Drafted 2 October 2012

**Planning Applications, Ribble Valley District**  
**3/12/0813 Higher Flass Farm Settle Road, Bolton by Bowland**

**Promap**

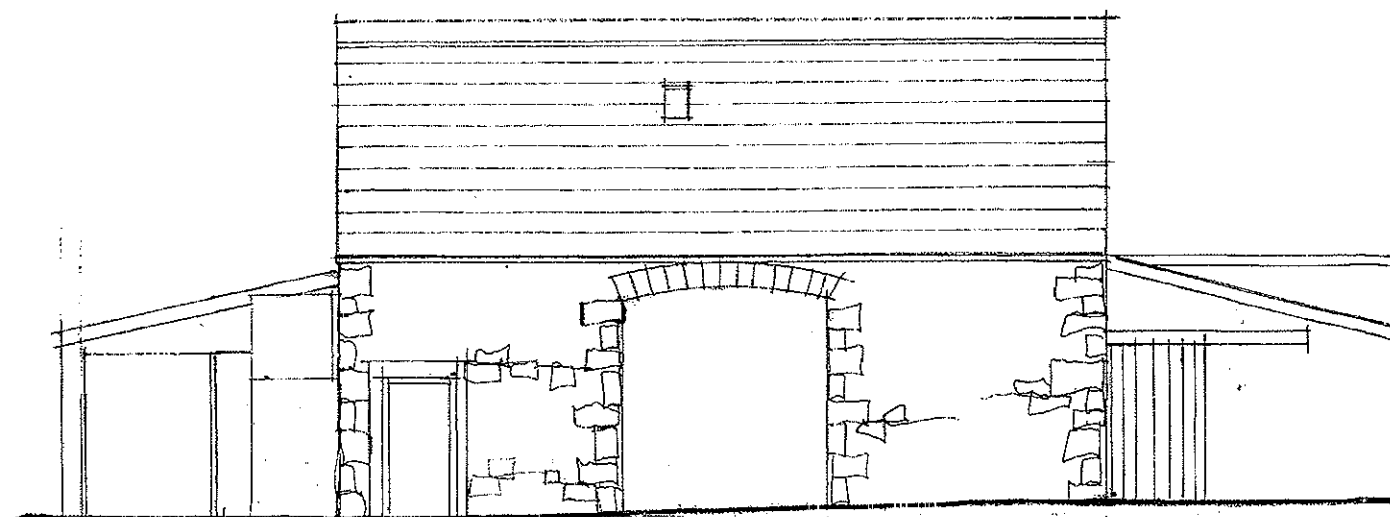
The applicant identifies off street parking in the supporting documentation. However, the site plan does not show in adequate detail the available provision of driveway parking and manoeuvring to secure safe movement to/from Settle Road in a forward gear.

I would be grateful therefore if an amended site plan was provided that showed the location of all proposed off street parking for this development.

125 - 02

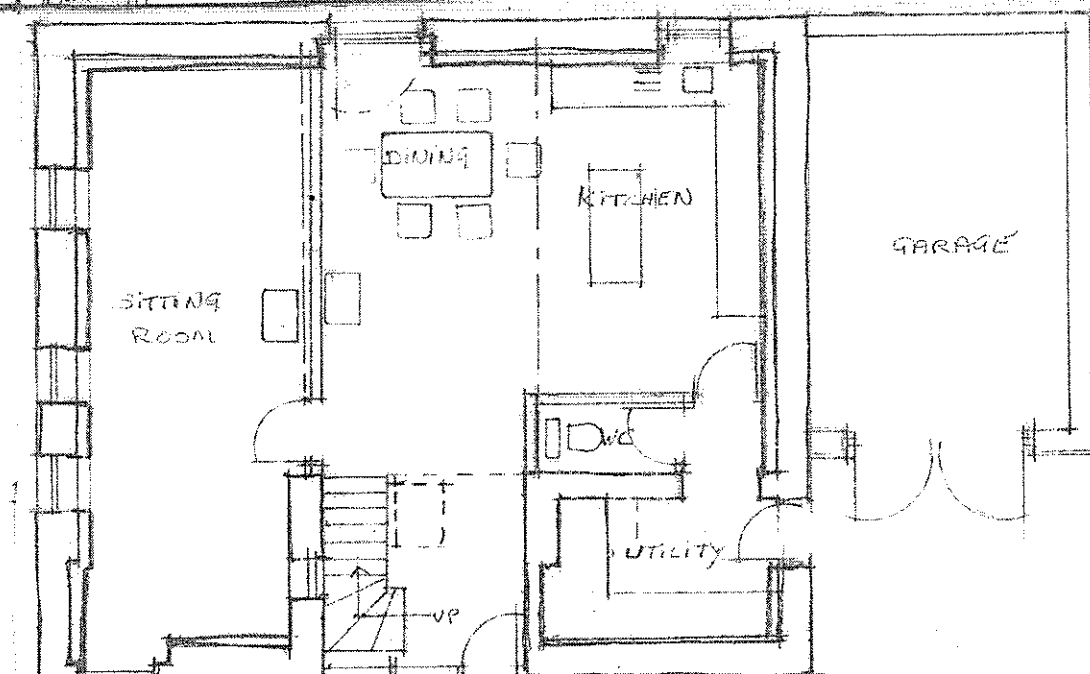
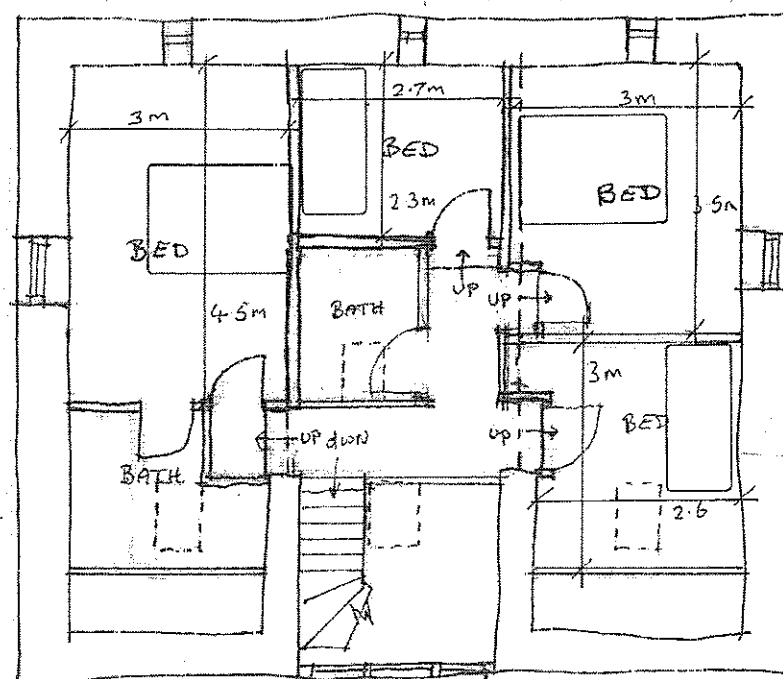
In order to retain the intended use of the garage in perpetuity, I would recommend that the following Condition should apply to this application:-

1. A Condition to be attached to any successful application that seeks to retain the use of the garage for its intended purpose in perpetuity and to prohibit any future conversion to residential living space.
